Submission Form

Epping to Thornleigh Third Track Proposal. Application number SSI 5132.

Figure 5.6 Cross-section and elevation - New Cheltenham Station concourse building
Note: Indicatively added to future design

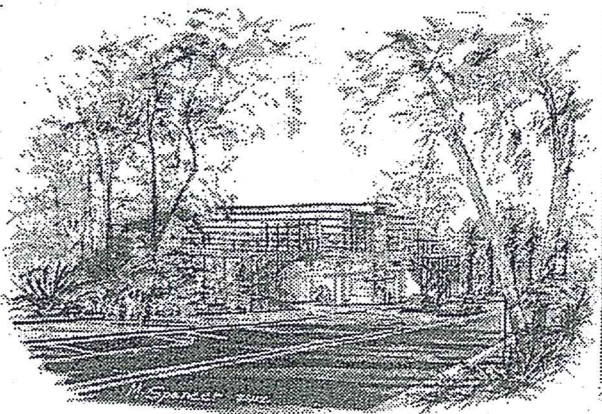
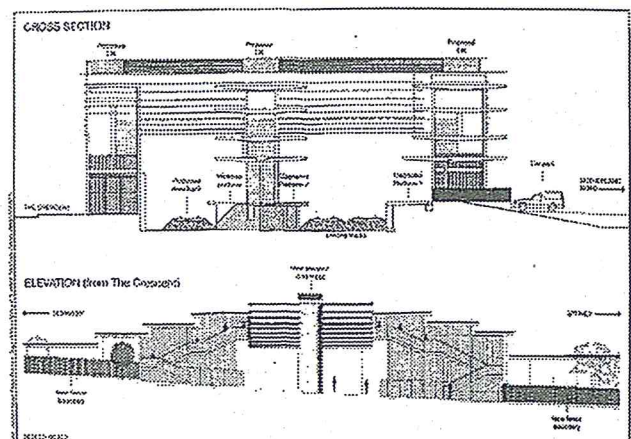
- The proposed redevelopment of Cheltenham Station shows no regard for the HCA. The visual impact of the proposed 13m high glass and steel concourse is totally unacceptable in this HCA.
